KITTITAS COUNTY FIRE MARSHAL'S OFFICE

May 24, 2011

Re: Childs (BL-11-00008)

**BOUNDARY LINE ADJUSTMENT**  
PREPARED FOR  
ROGER CHILDS  
A PORTION OF THE WEST 1/2 OF  
SECTION 1, TOWNSHIP 19 N., RANGE 14 E., W.M.  
KITITAS COUNTY WASHINGTON  
DWN BY G. WEISER DATE 04/2011 JOB NO. 04572-1  
CHKD BY D. NELSON SCALE 1"=100' SHEET 1 OF 2

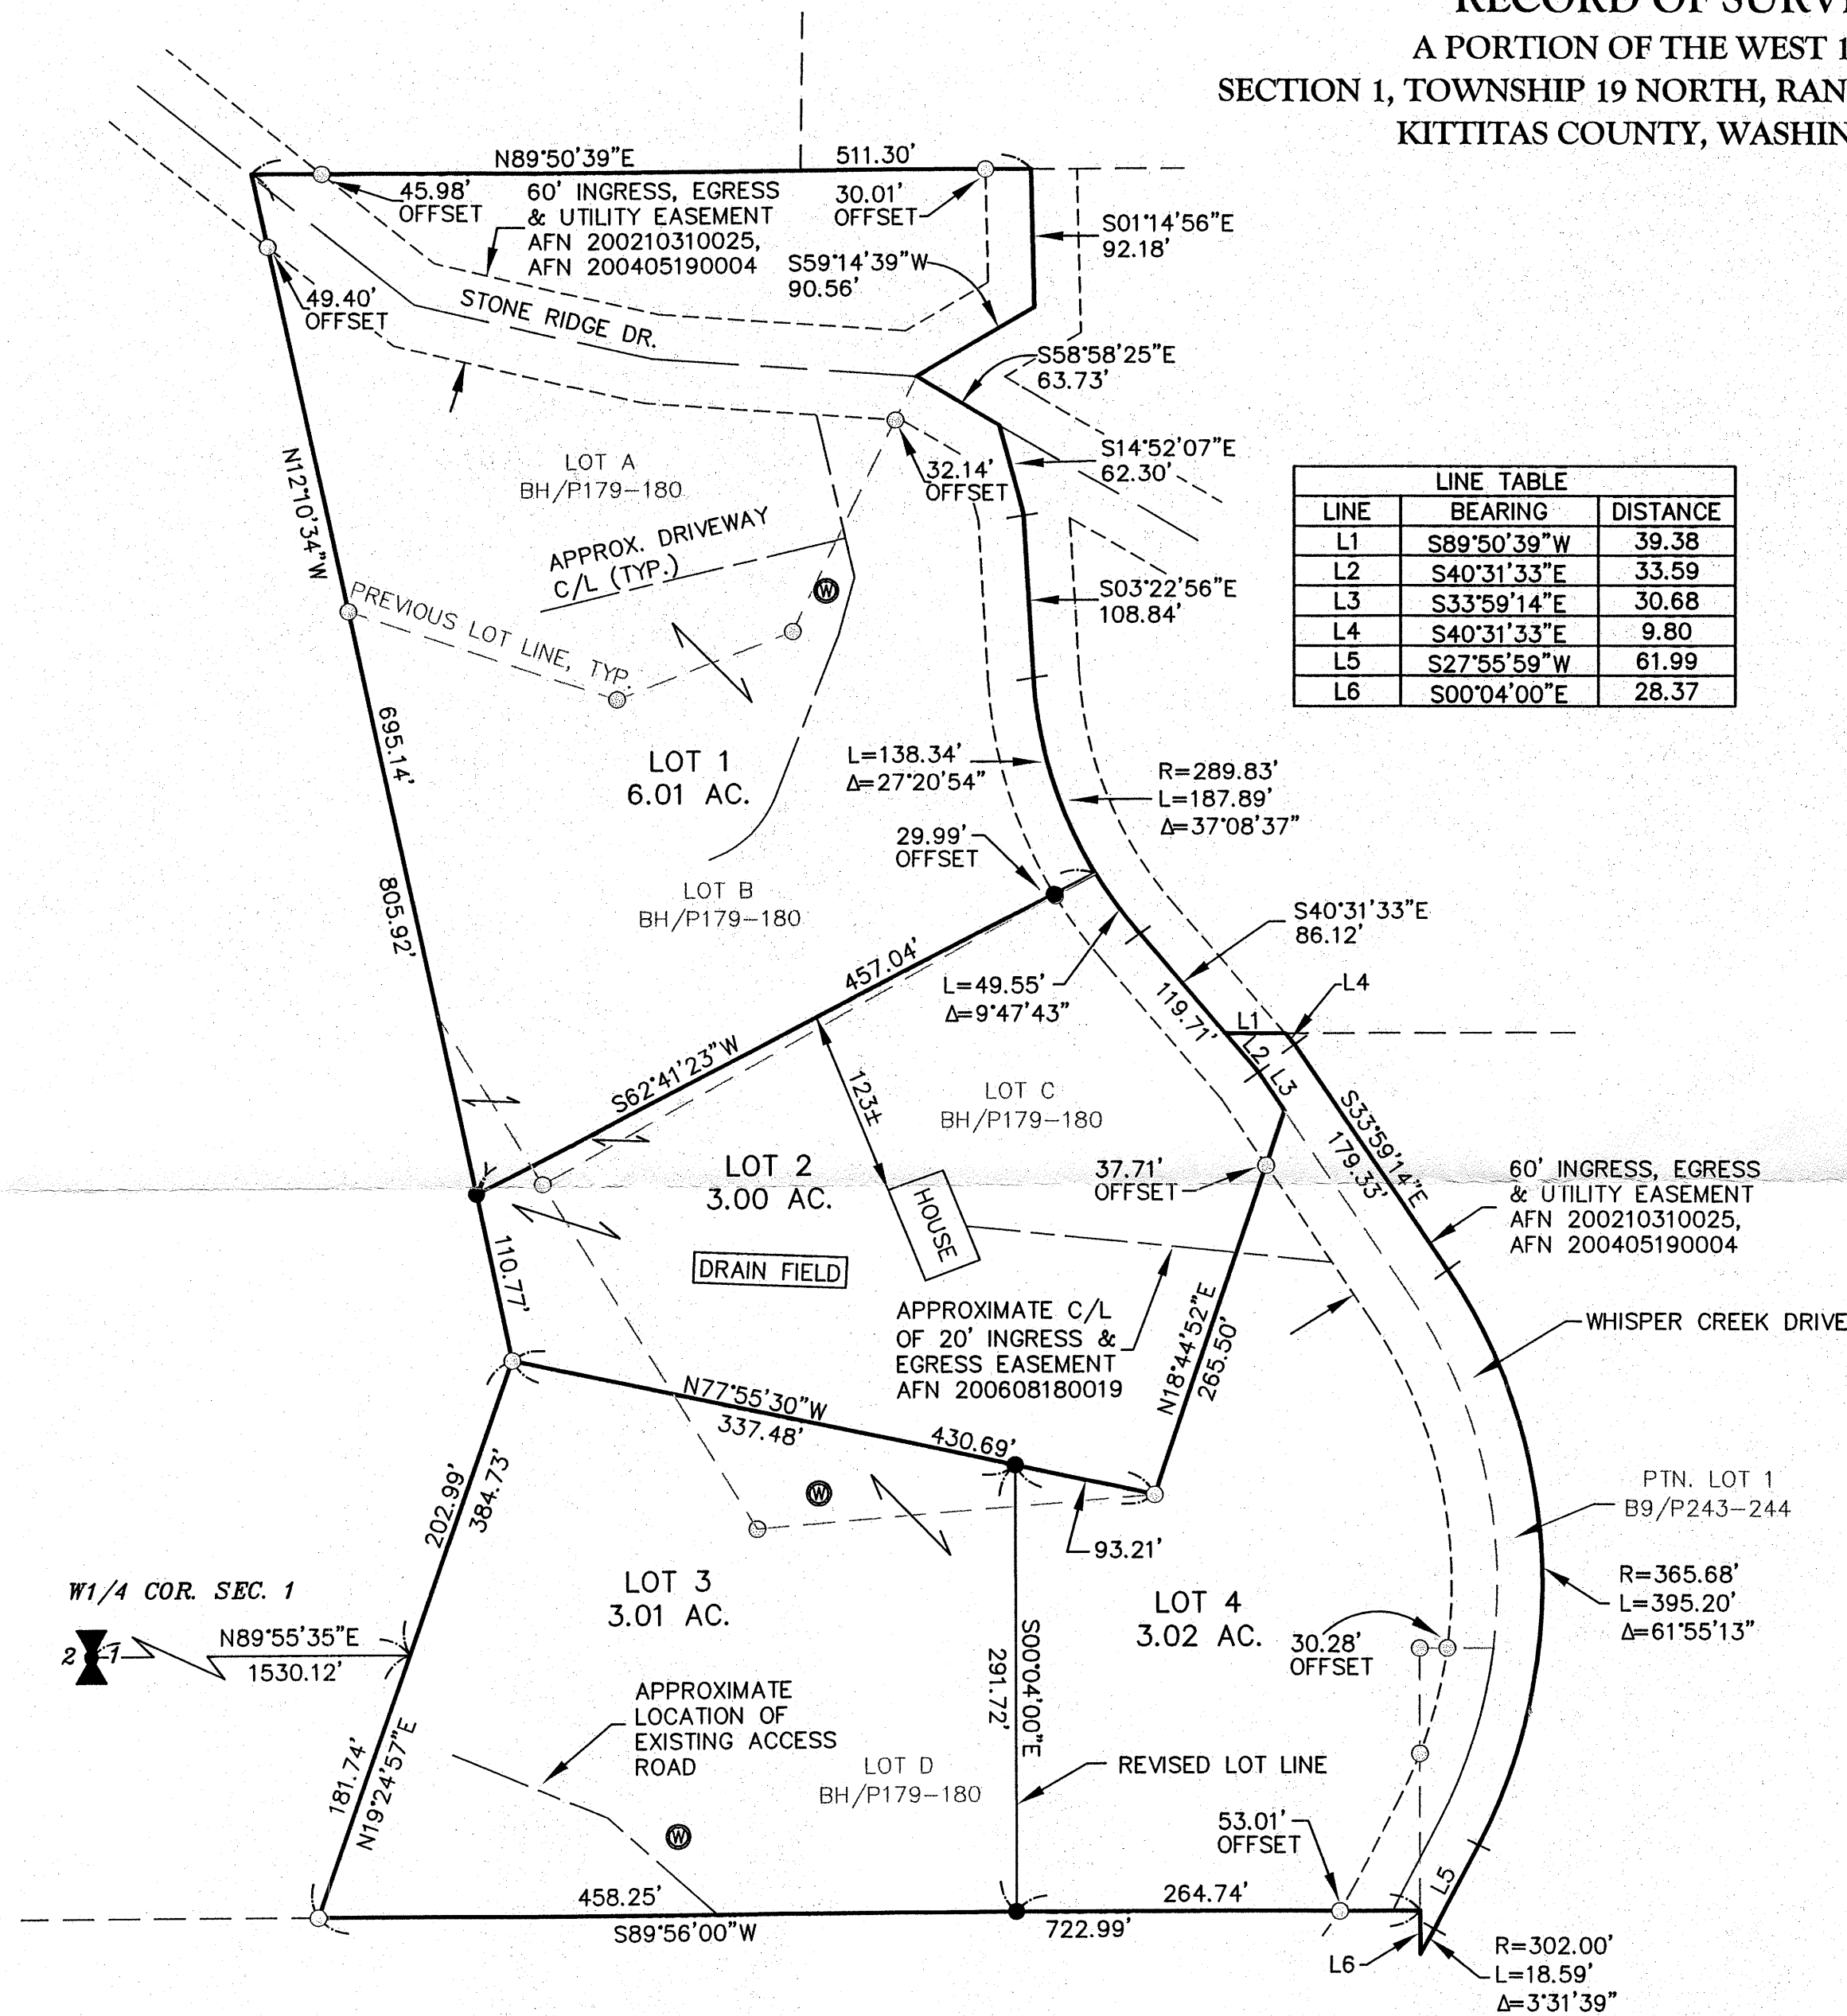
- Ensure that boundary line adjustments do not infringe upon existing structures, to include propane tanks, etc.
- Creation of any additional roads or access must comply with the International Fire Code.
- All future development must comply with the International Fire Code.
